Item No. **Report of the Head of Planning, Transportation and Regeneration**

Address 1372 UXBRIDGE ROAD HILLINGDON

Development: Three storey building for use as 3 x studio flats and 2 x 1-bed self contained flats, installation of 2 x vehicular crossovers and demolition of existing two storey building

LBH Ref Nos: **5625/APP/2019/917**

SCALE 1:50 @A1	DRAWING No.	REV.
DATE MAR '19	4971-9	A
DRAWN LK		
CHECKED DV

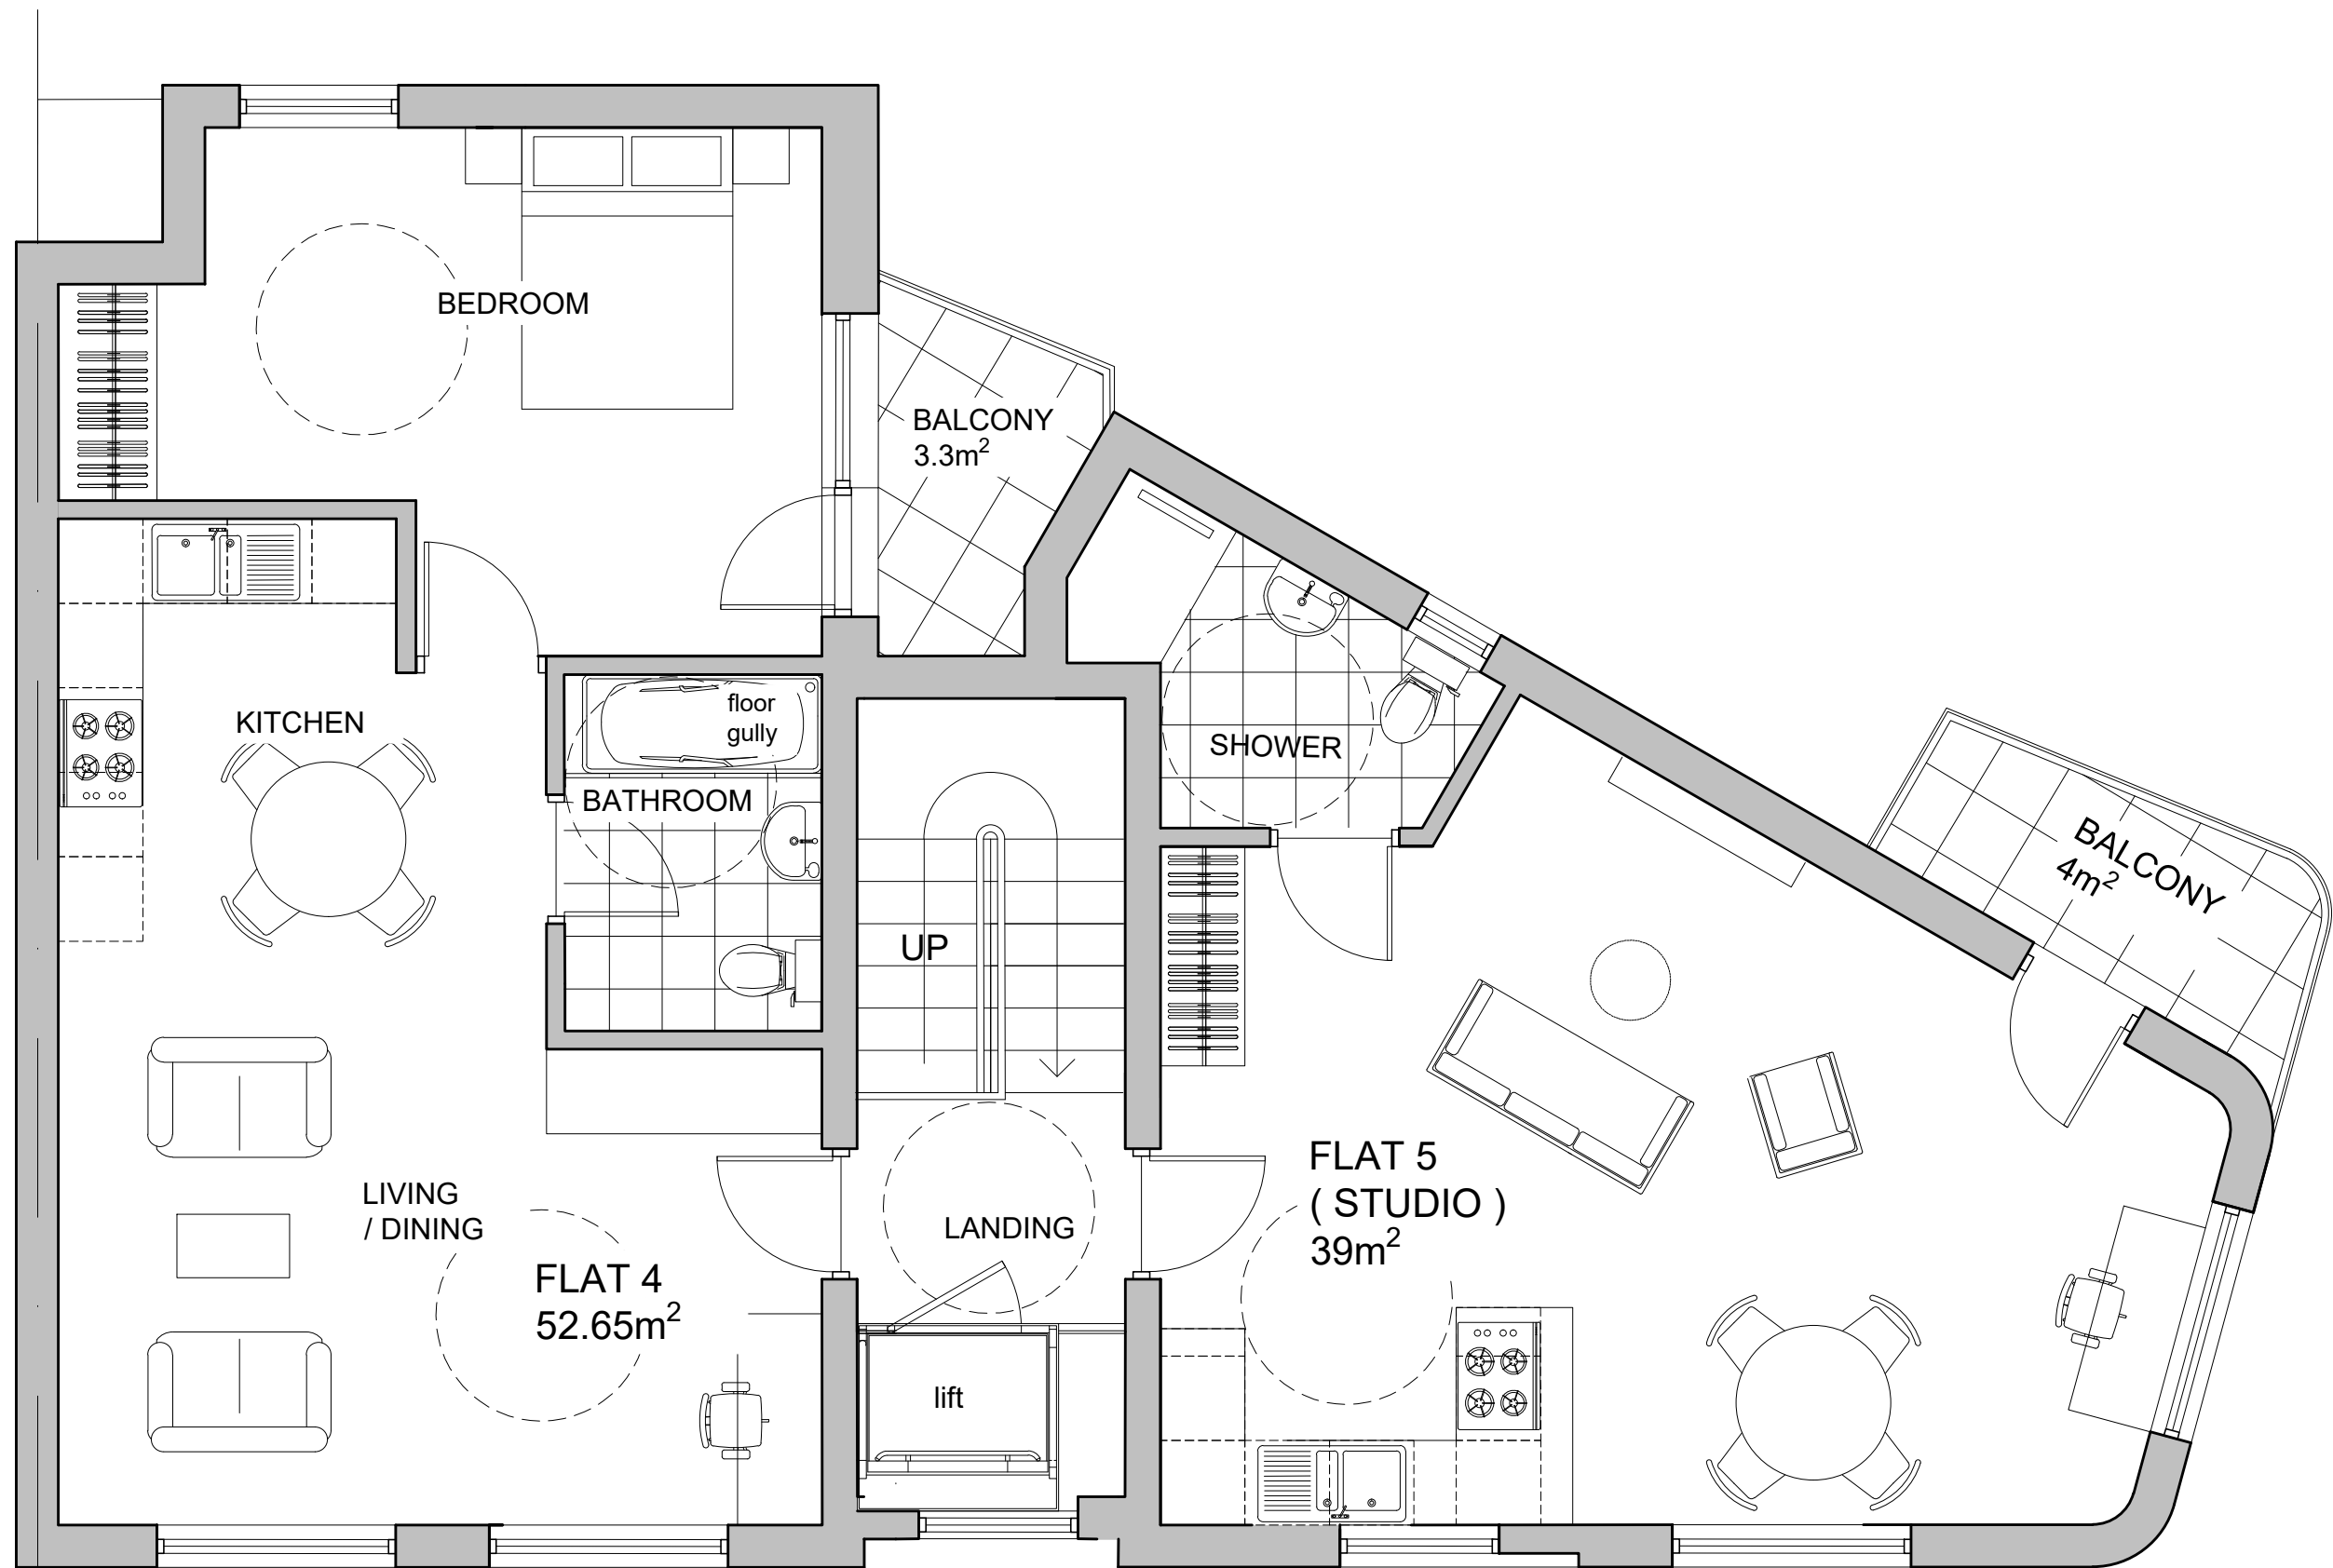
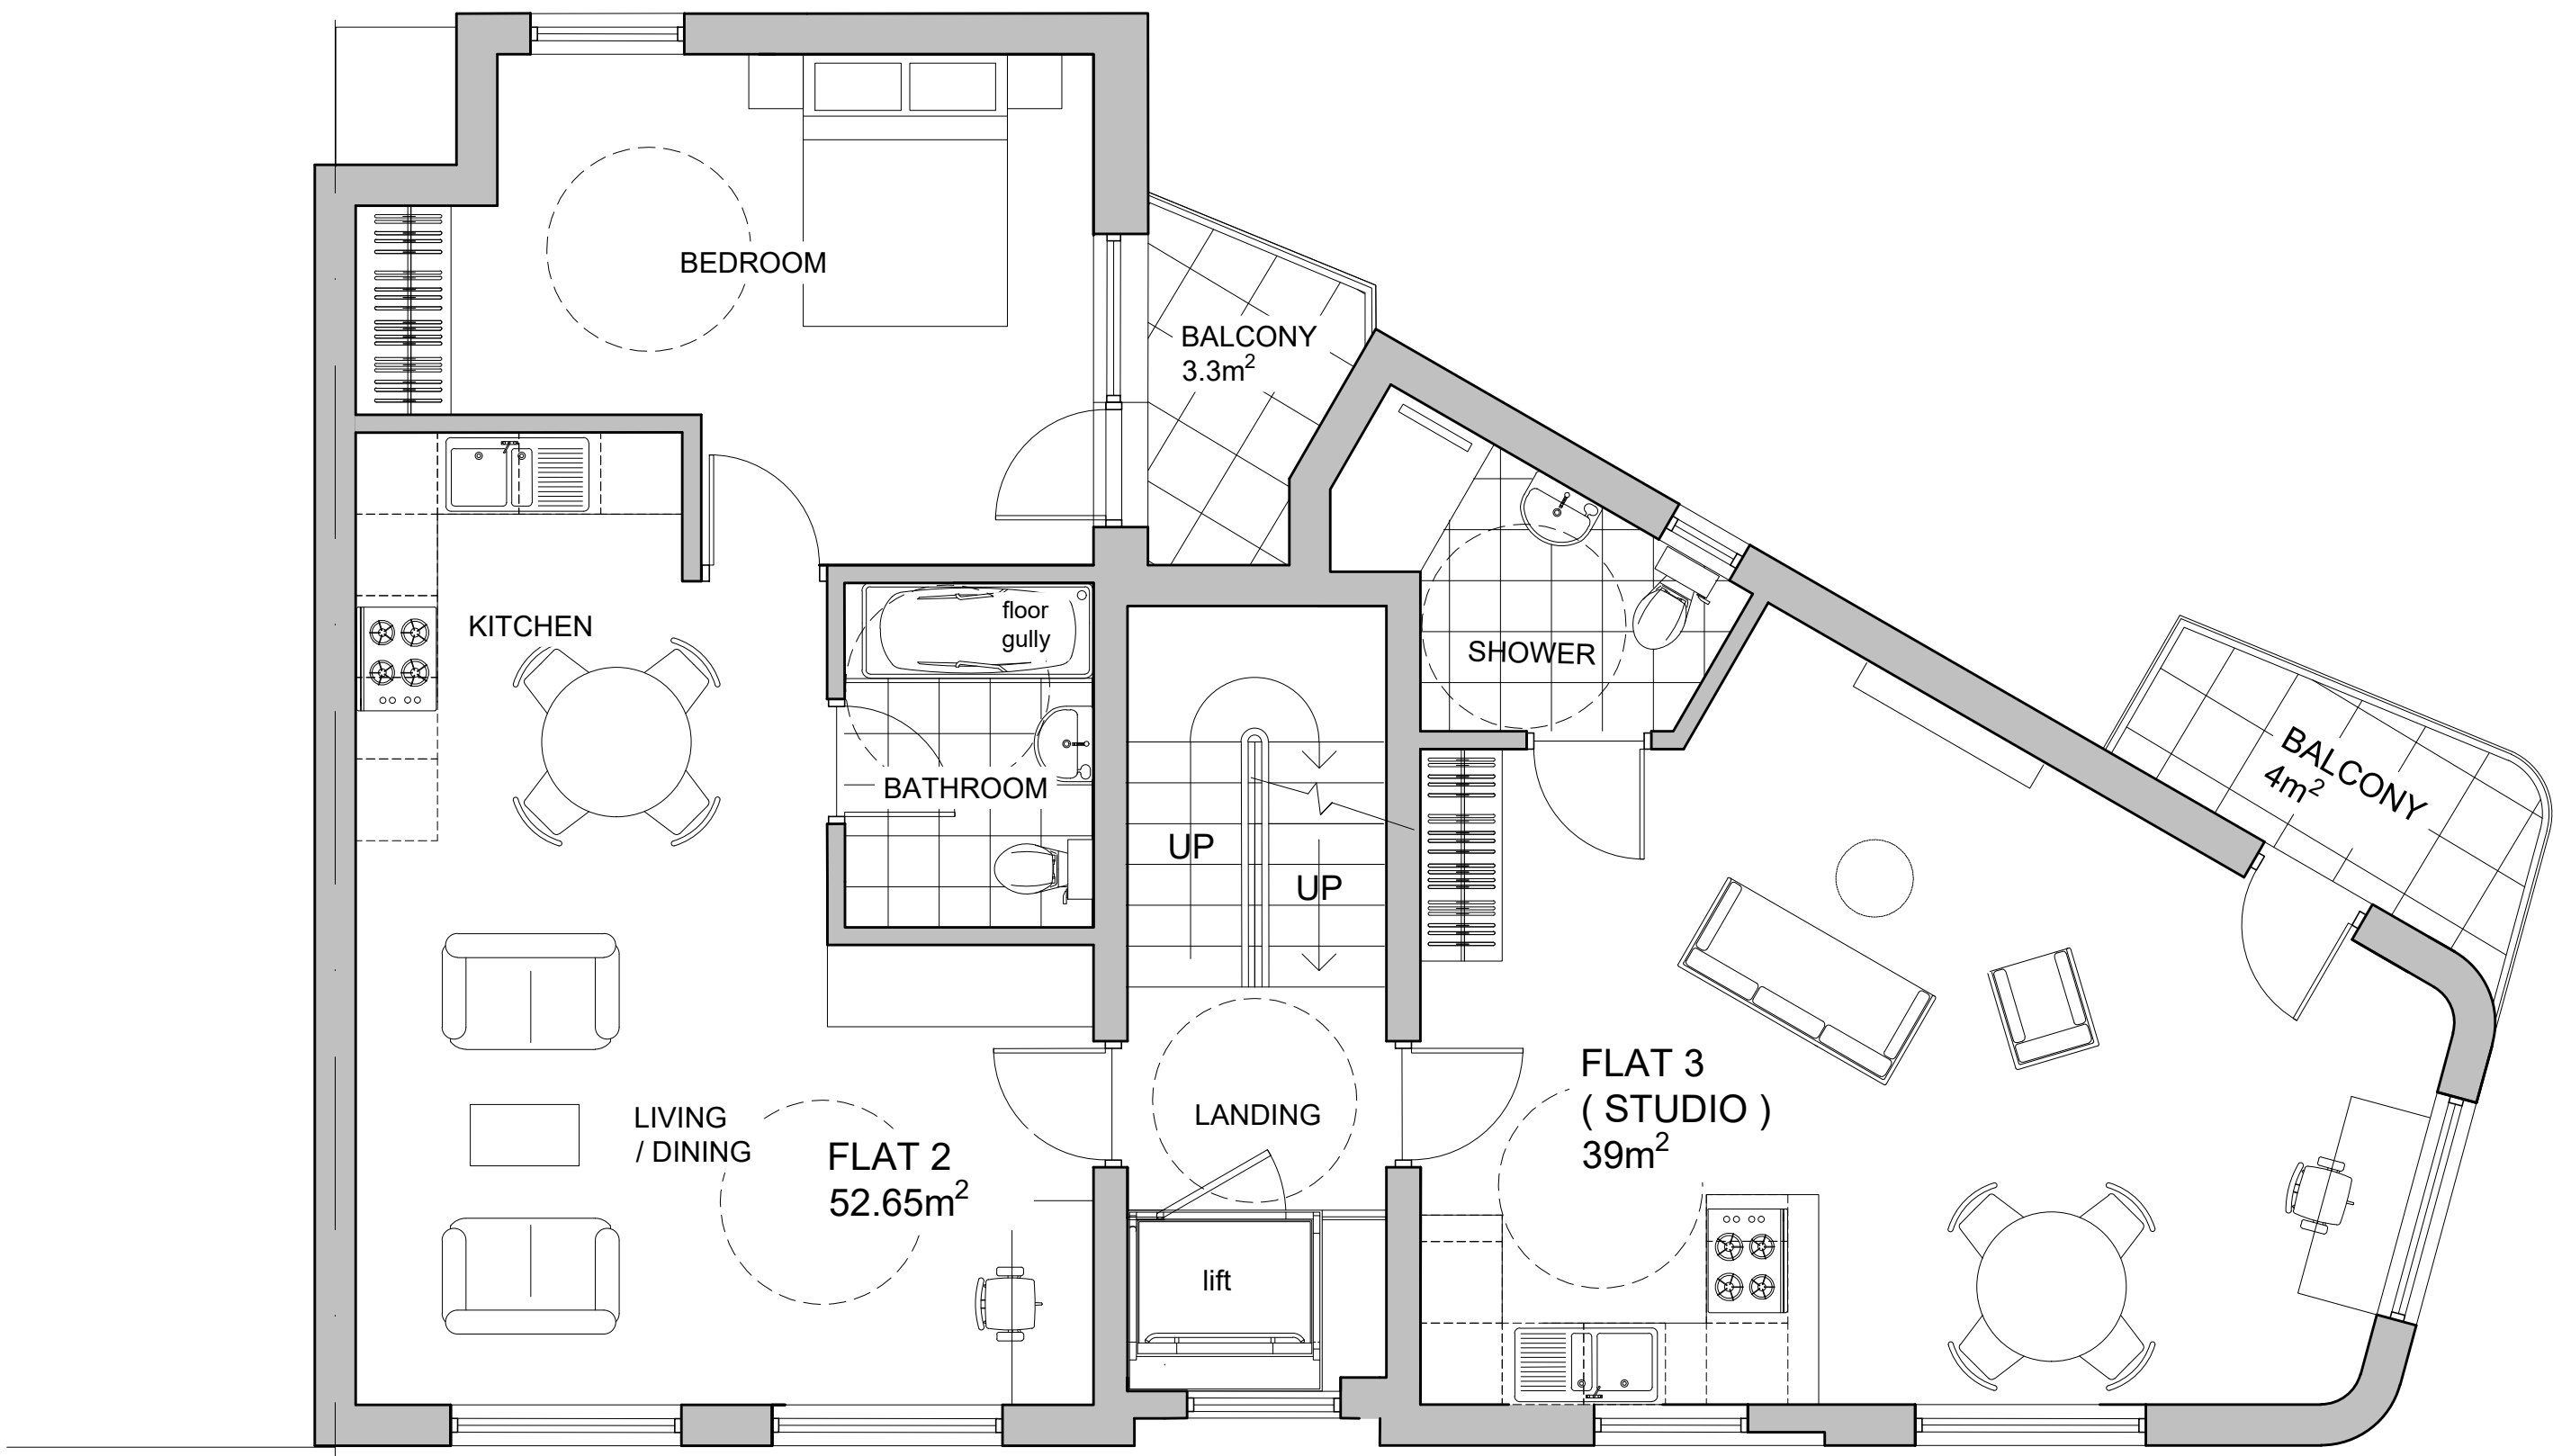
There are 4 spaces proposed consisting of 3 on-plot and 1 space on the public highway. By law it is not legally possible to allocate a parking space for an individual or specific address on the public highway hence the single parking space proposed on Hewens Road is considered unacceptable and should be removed from the submission. As the space falls outside of the site envelope there is a 'true' proposed on-plot provision of 3 spaces.

Having reviewed this application, it is clear that step free access to the proposed dwellings above ground floor would not be possible for wheelchair users and other persons unable to use a staircase. Paragraph 3.48A of the London Plan (March 2016) recognises that the application of M4(2), which requires lift access (a step free approach to the principle private entrance), may have particular implications for developments of four storeys or less where historically the London Plan may not have required a lift. Local Planning Authorities are therefore required to ensure that dwellings accessed above or below the entrance storey in buildings of four storeys or less have step-free access. Research indicates that the provision of a lift does not necessarily have a significant impact on viability and does not necessarily lead to a significant increase in service charges. However, in certain specific cases, the provision of a lift where necessary to achieve this aim, may cause practical difficulties, make developments unviable and/or have significant implications for the affordability of service charges for intended residents. Unless the applicant submits a clear, well evidenced and compelling case to the LPA as to why lift access cannot be provided, the application should not be supported on the grounds of non-compliance with London Plan policy 3.8(c). Conclusion, unacceptable

Officer note: Amended plans have been submitted to include the provision of a lift.

Amended plans have been submitted throughout the course of the application to include the provision of a lift to ensure that all 4 units would be accessible.
